ASSESSMENT REPORT

Sydney International Convention, Exhibition and Entertainment Precinct (SICEEP), Darling Square (formally The Haymarket) and the North West Plot, Darling Harbour

SSD 6013 MOD 3

Figure 4.01 : Section 96 NW Plot Proposed Level 12 Plan

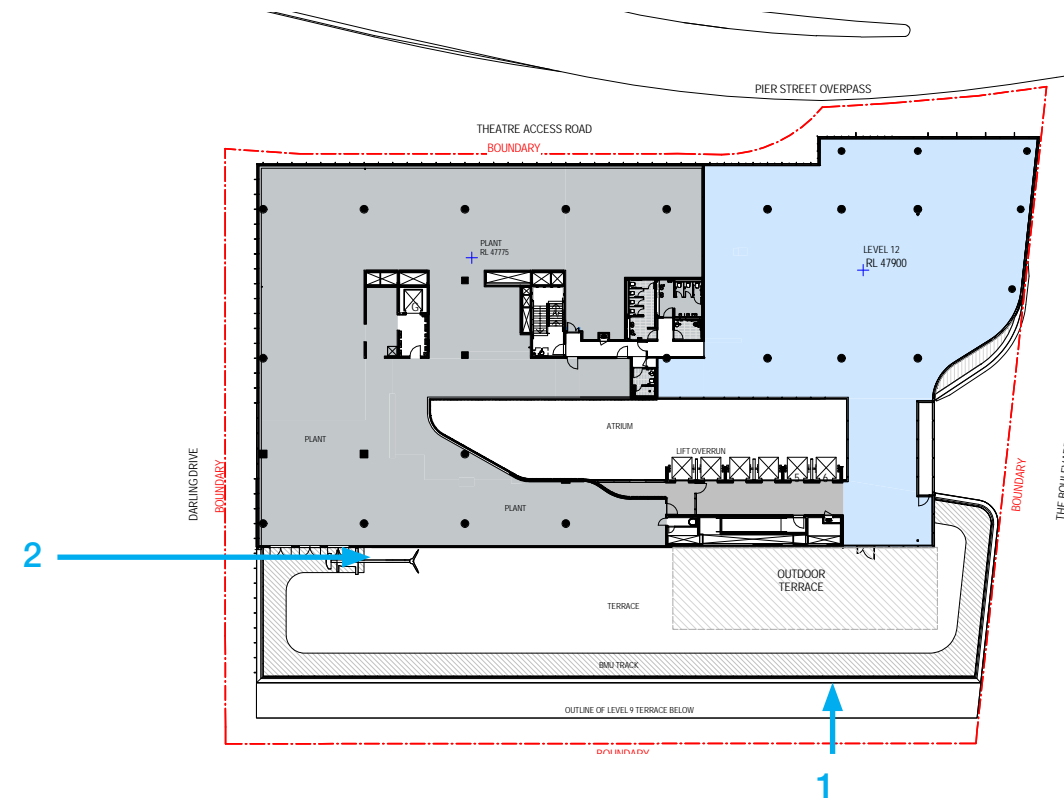
- roof level balustrading, suggesting it be set back to reduce its appearance; and
- the Level 12 terrace landscaping, suggesting it should be provided to a high standard as it would be visible from surrounding buildings and the public domain.

With regard to the terrace area at Level 12, the applicant argues the proposed landscaped deck area will significantly enhance the amenity of this space and provide an improved visual outcome.

Given the location of the terrace at roof level, the Department does not consider it would be highly visible from the public domain. The Department is satisfied the amendment to the Level 12 terrace area provides a high quality landscaped environment which would make a positive contribution to the visual appearance of the site when viewed from the public domain or surrounding buildings.
